**Your Ref:** OWPC23966  
**Our Ref:** EP/84/19/HH 03-07-2019  
**Please ask for:**  
Zac Denton

Two storey front extension (North), two storey side extension (West) and single storey rear extension (South). Alterations to external appearance, roof terrace over existing flat roof, roof lantern in existing flat roof & Juliette balcony to front of property.

10 Angmering Lane East Preston

Thank you for your internet representation made on 7th August 2019 which has been recorded as '**an objection**' with the comments as follows:

Drawing Title:
Proposed Plans, Elevations and Site Block Plan

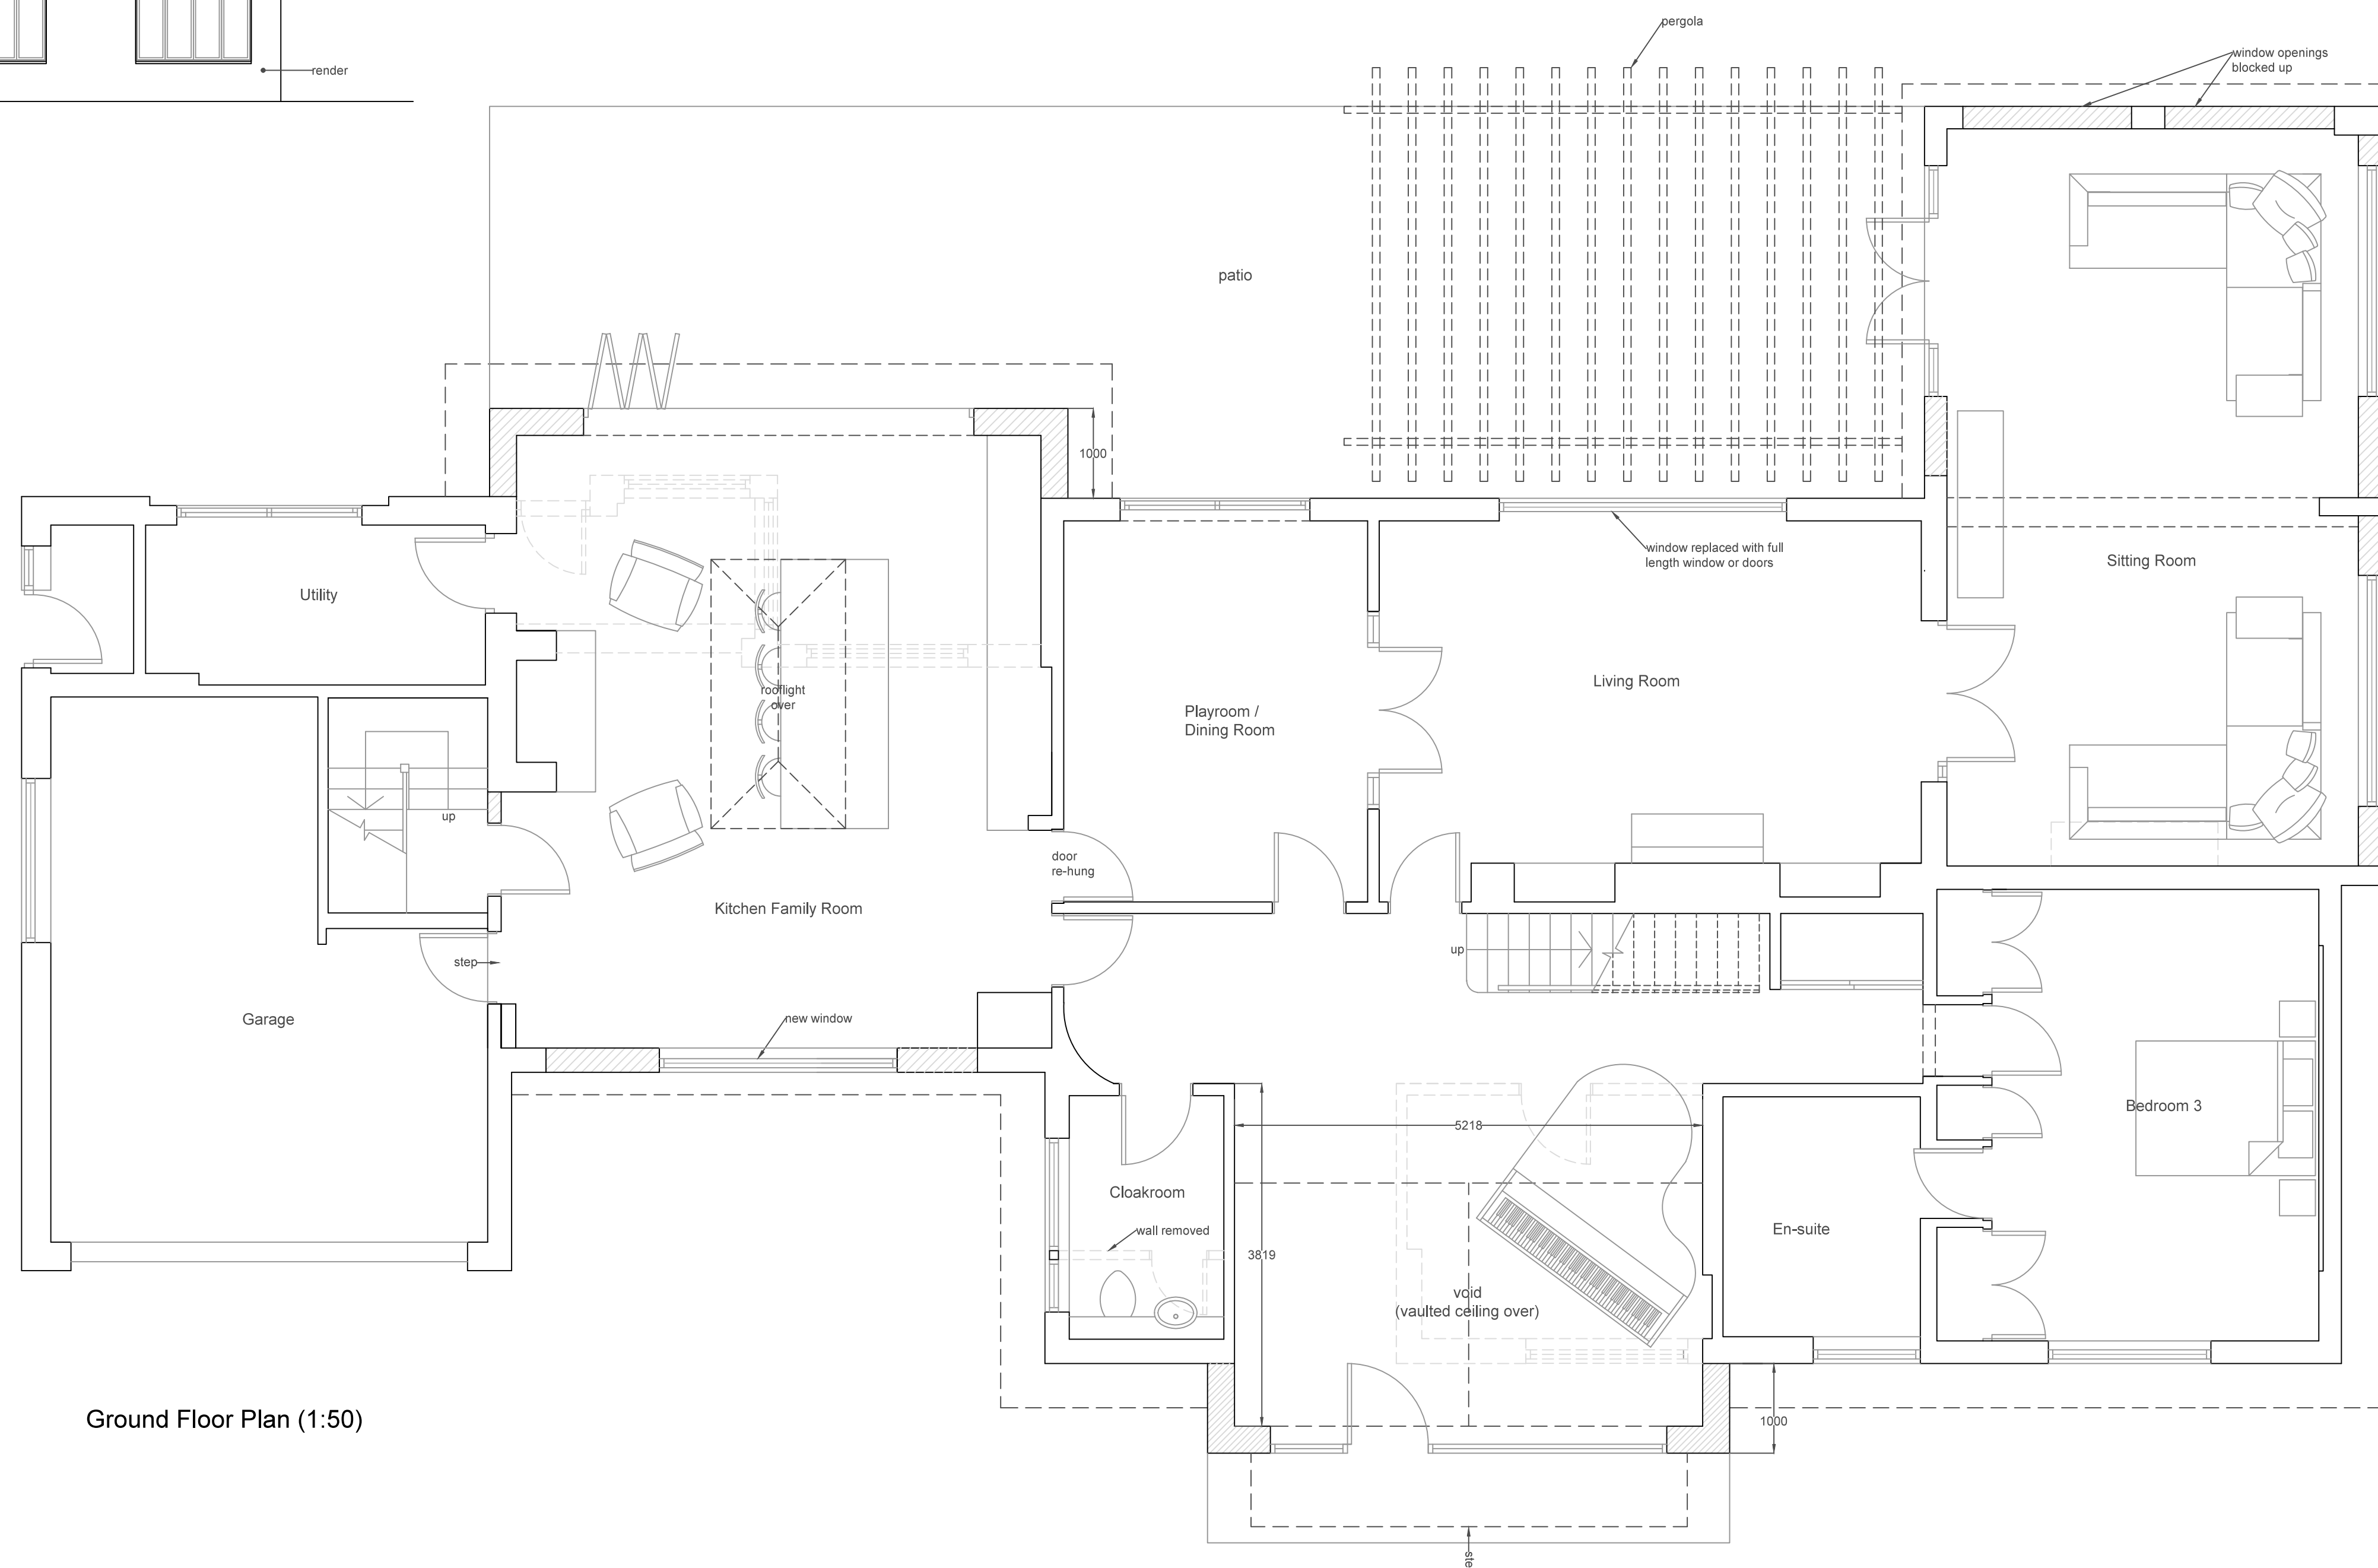
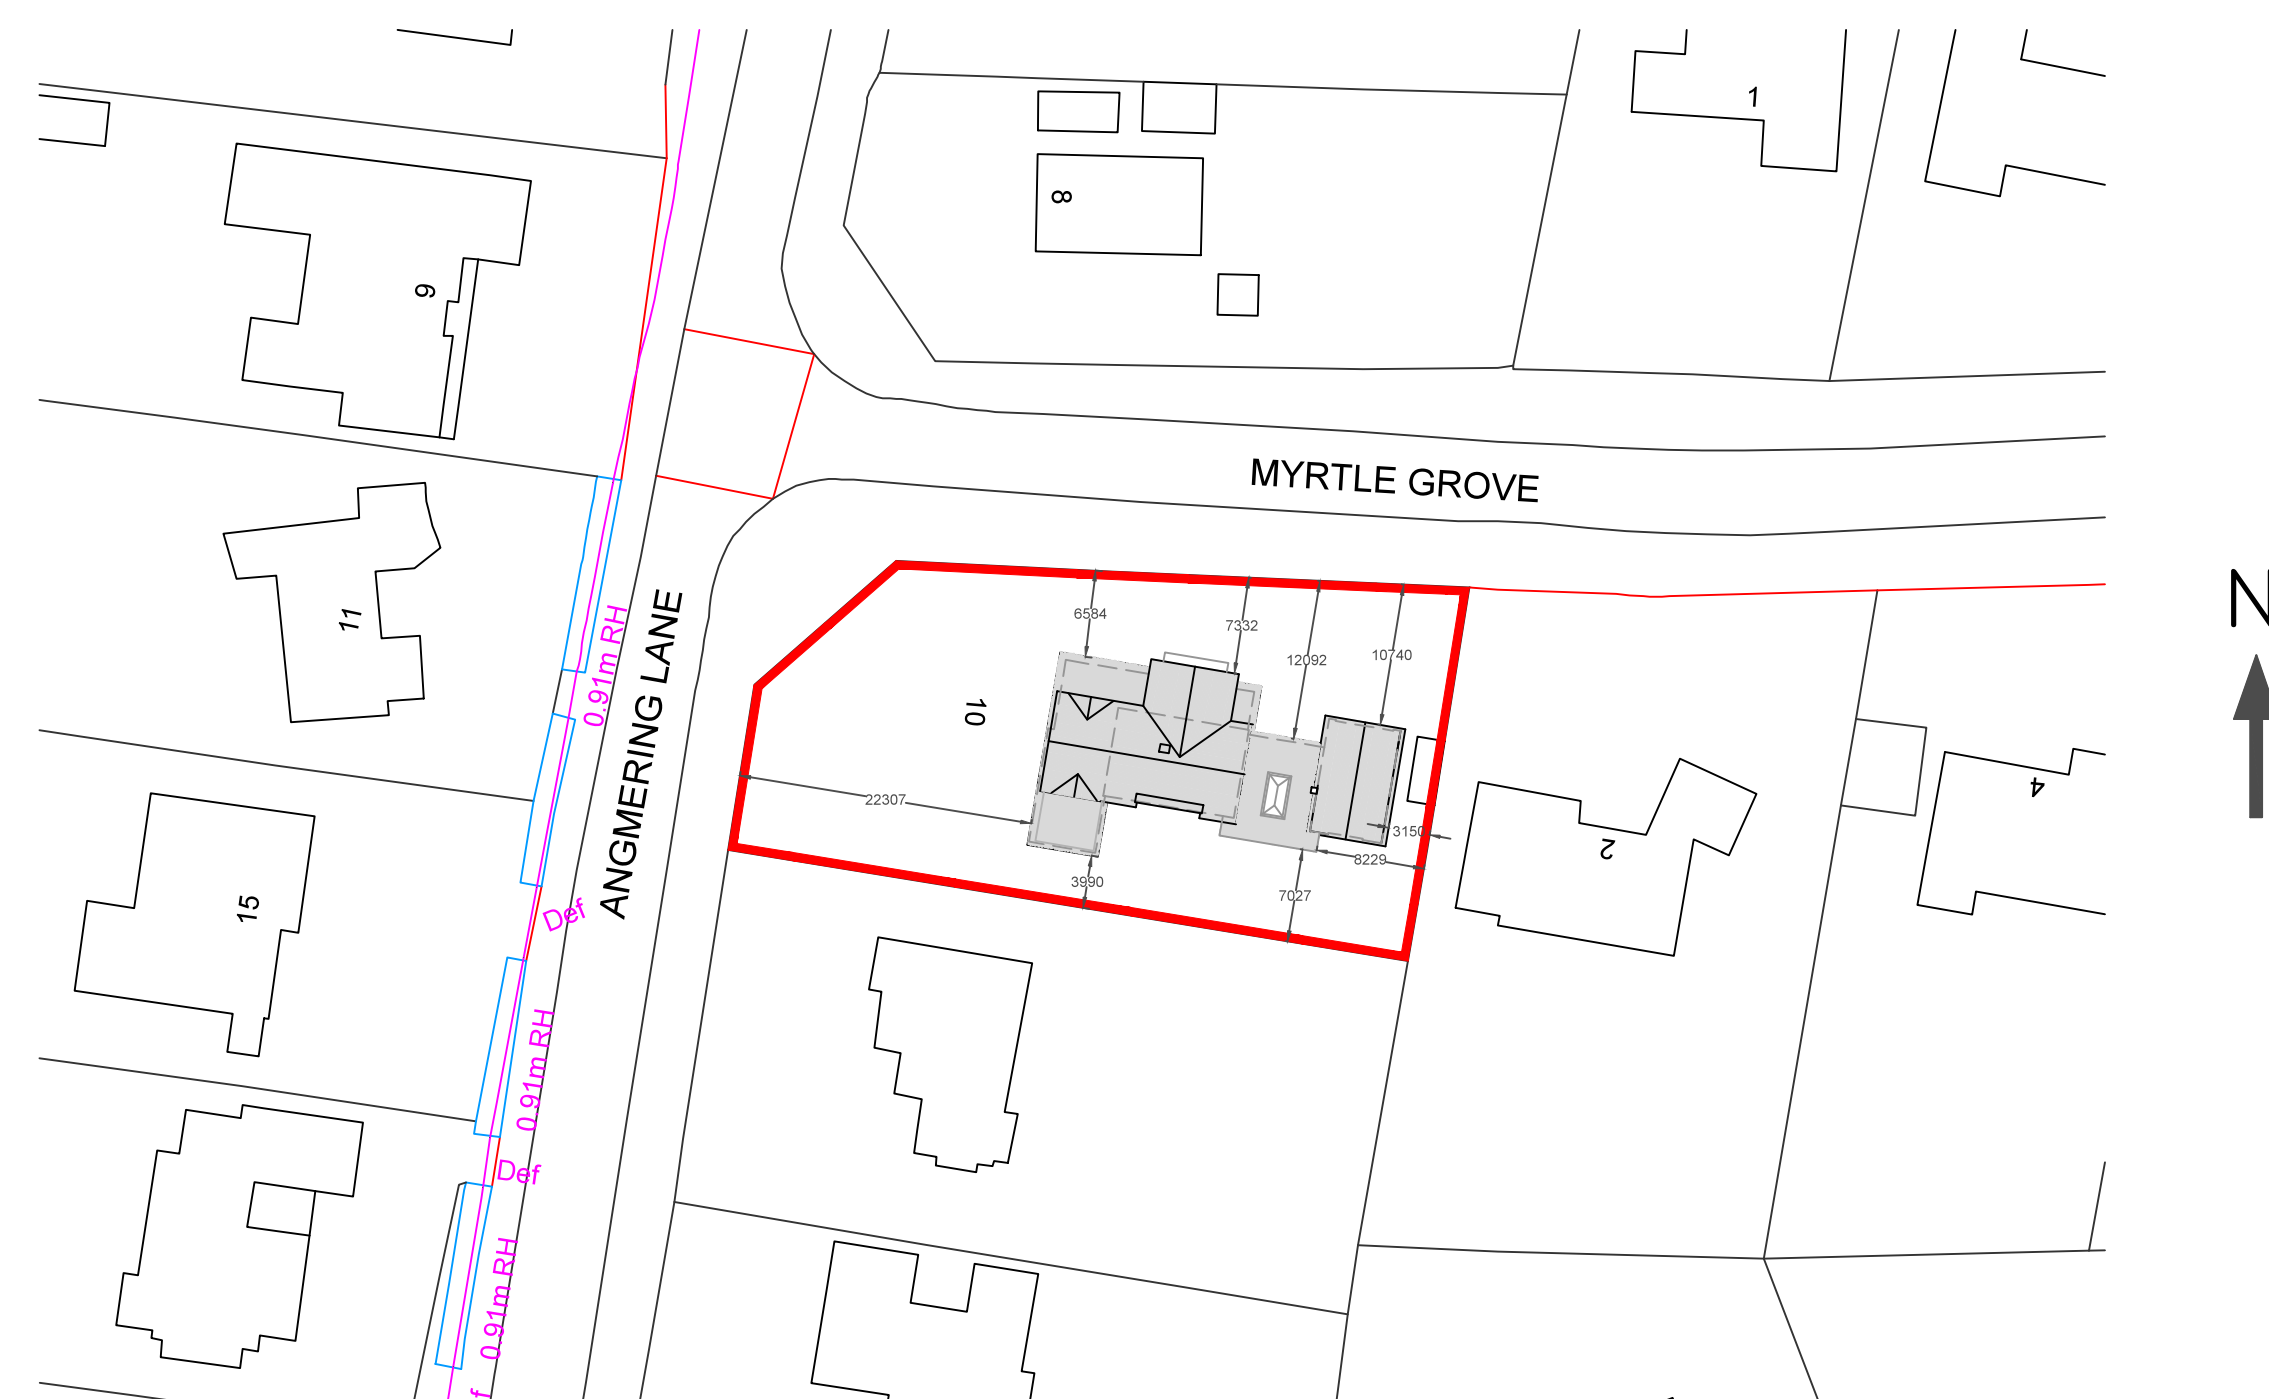
*The design of this house is characterised by the use of grey roofing tiles and windows, and extensive use of white plastic on other features of the facade. The result would be a house that did not reflect the character of the surrounding area in terms of the colour and texture of the materials used. The house would therefore contravene Policy D DM (1) of the Arun Local Plan.*
